HINCKLEY NATIONAL RAIL FREIGHT INTERCHANGE

Project reference TR050007

Applicant's response to deadline 3 submissions [Part 2 - HBBC]

Document reference: 18.13

**Figure 11.17 - Illustrative Landscape
Sections AA to GG**

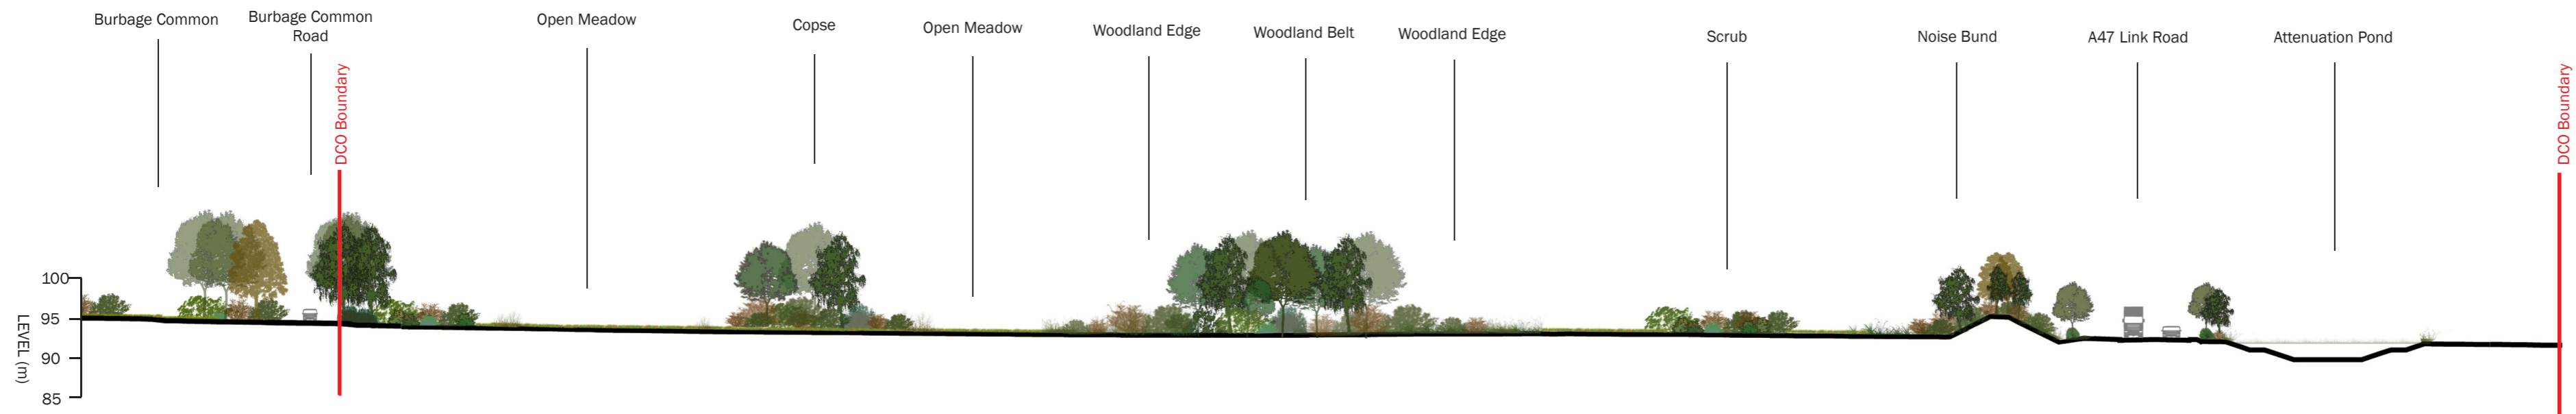
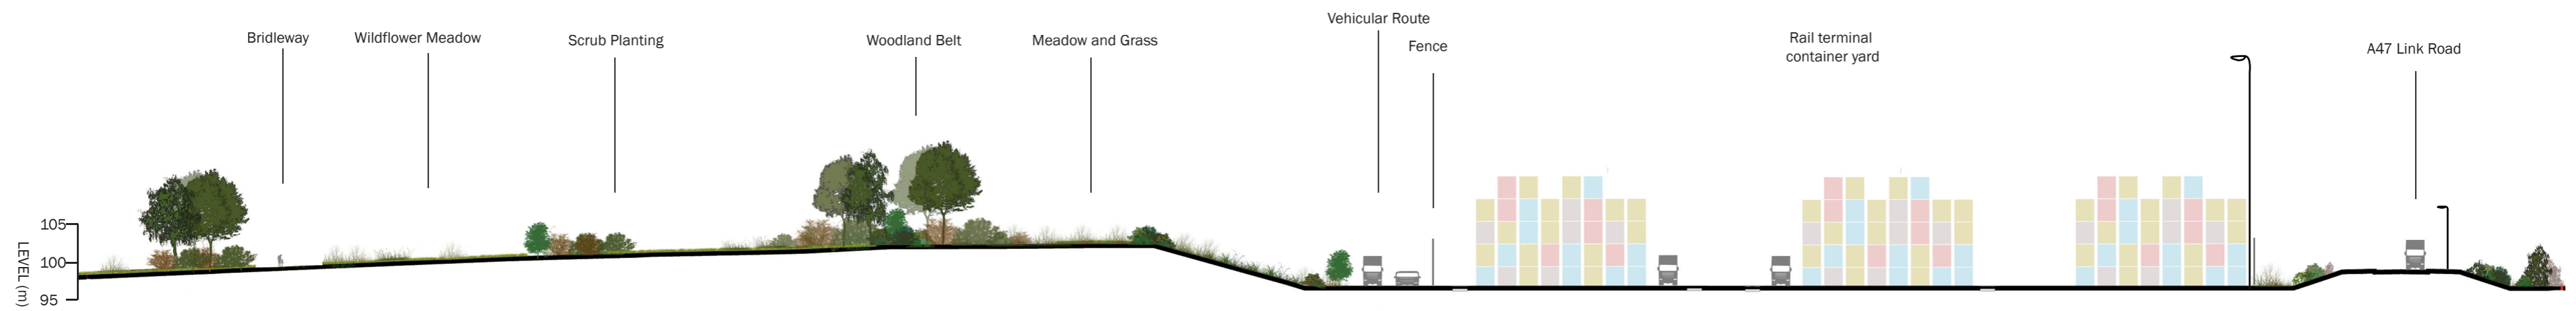
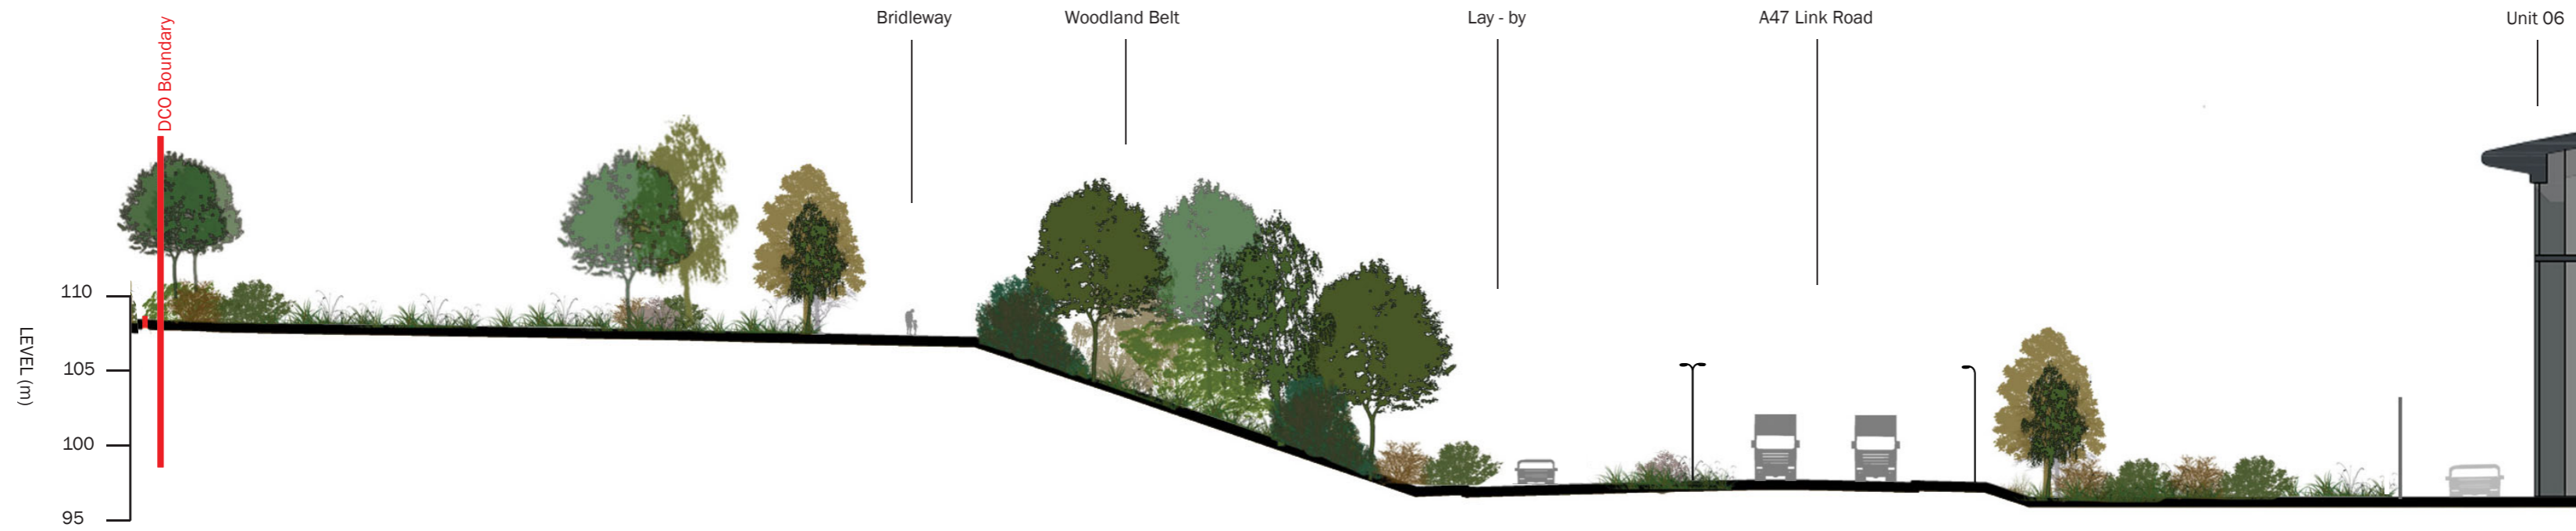
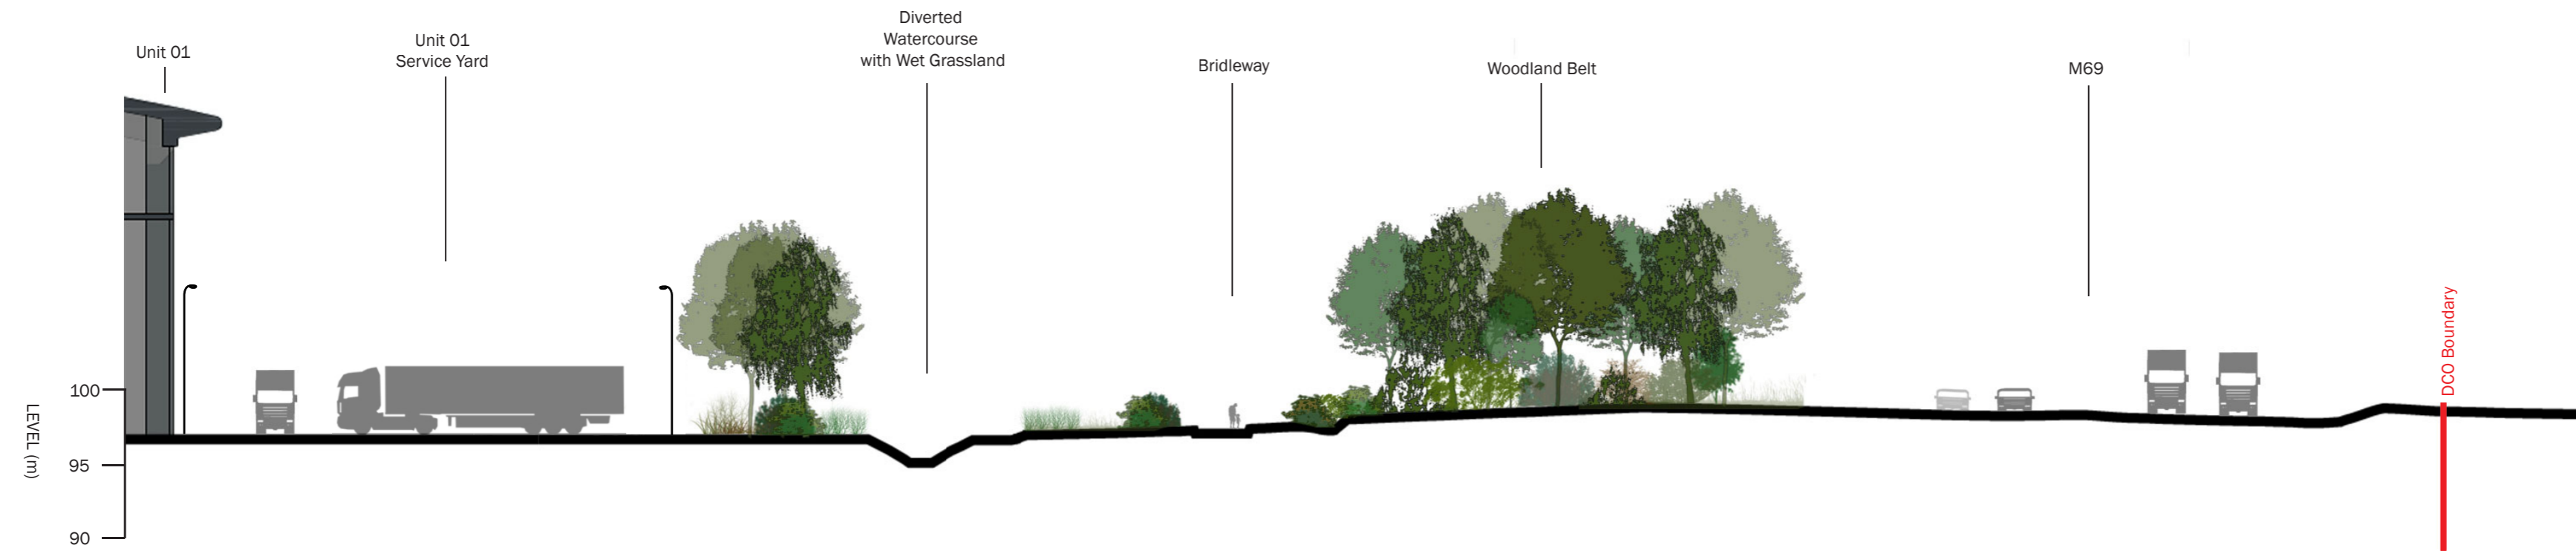
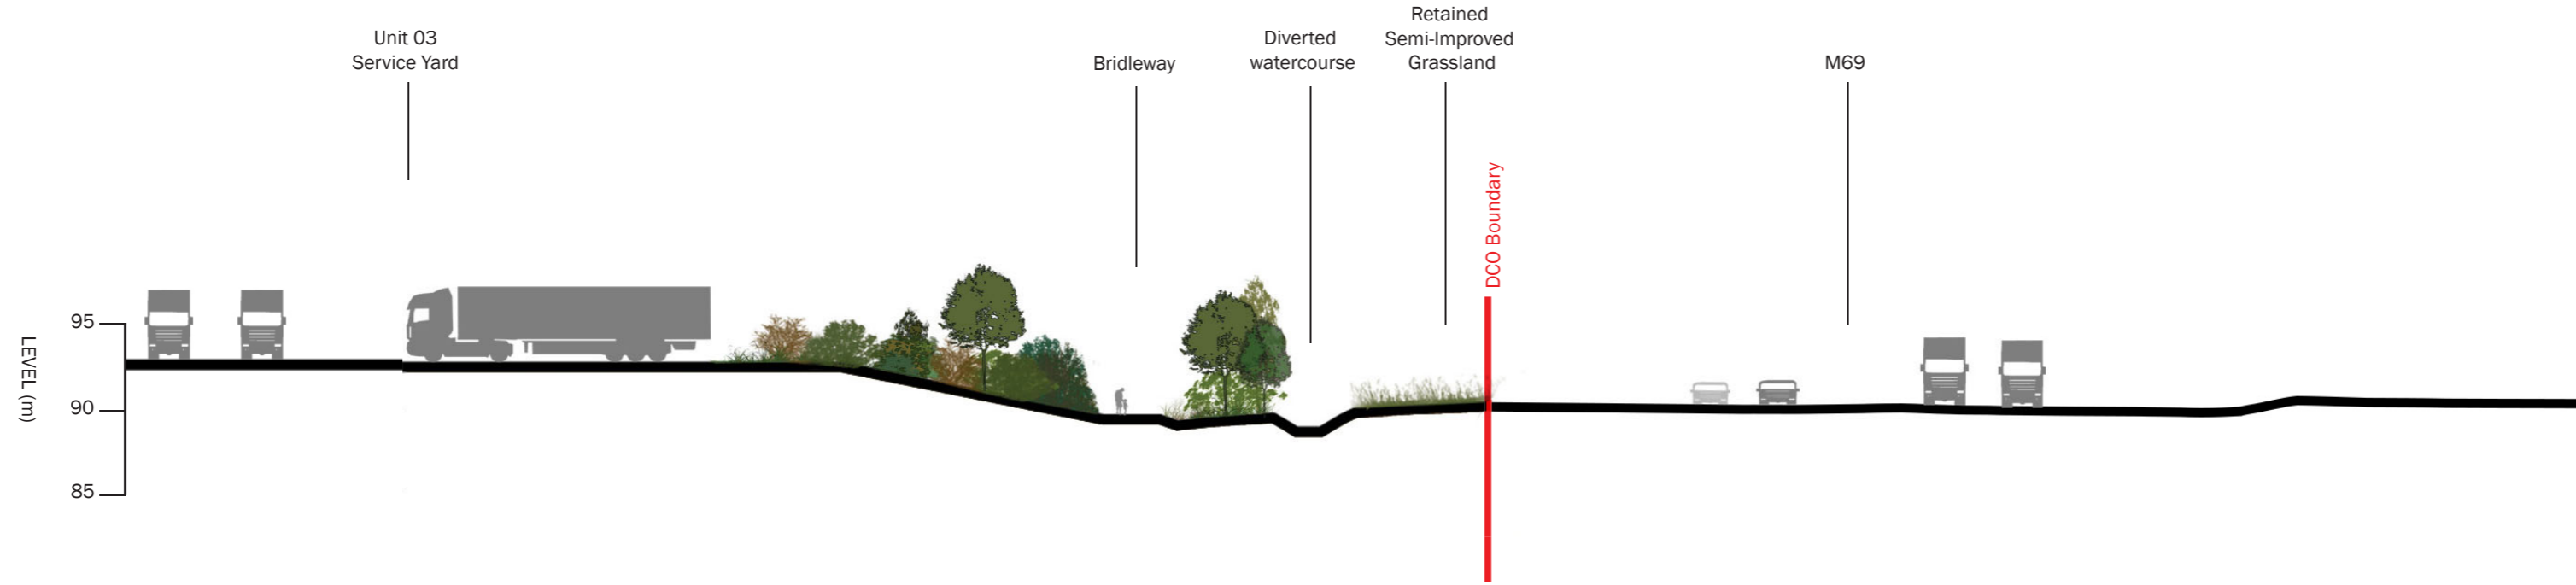
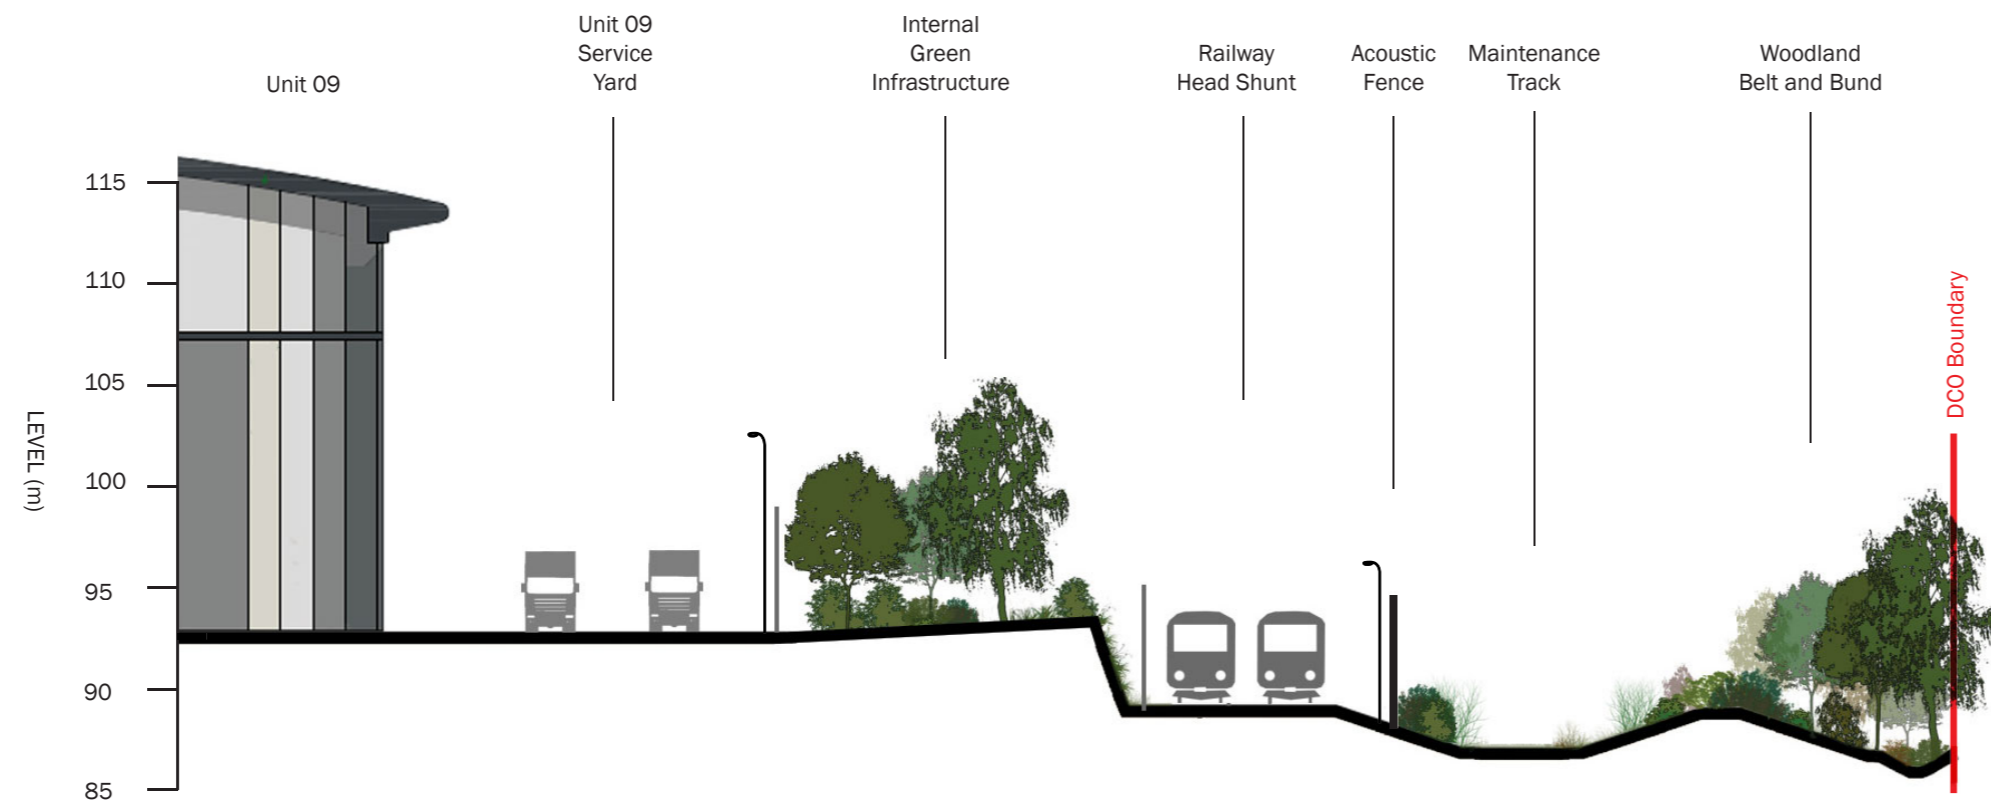
5	HBBC states that the height (28m) and scale of the development means that planting along boundaries is not effective in screening or filtering views of the development.	Not agreed, the boundary planting will be very effective at screening views of much of the development over the longer term, particularly the lower active zone where movement of trains, HGV's and containers would otherwise be a distracting feature in views from the surrounding area.	The upper parts of the proposed development (e.g. roofline and gantries) will remain visible above proposed vegetation in the long-term, reflected in the large number of residual significant visual effects reported (as agreed within the draft SoCG).	Yes, this is agreed noting however that planting does serve to screen and filter the majority of the development.
6	HBBC believes that these visual effects will be experienced at a greater number of viewpoints than identified in the LVIA. The overall impact of the development on the landscape and visual amenity is negative.	The viewpoints are representative of what will be seen in the local area and are not intended to cover every possible view of the development. However, in this instance, many more views than would normally be selected have been included such that there is no general location where a public view might be experienced that isn't represented by a viewpoint.	The use of representative viewpoints and that these are not intended to cover every possible view is agreed. However, it should be noted that the extent of visual effects is larger than just the viewpoints selected (e.g. significant effects are reported for PRoW users at PVP 17 and similar significant effects would be experienced along almost all of the PRoW between Billington Rough and Burbage Common Road, not just where the viewpoint is located).	The ES does not suggest that this is the case. It clearly sets out the receptors with significant effects in Tables 11.17, 11.19 and 11.21 (document reference 6.1.11A).
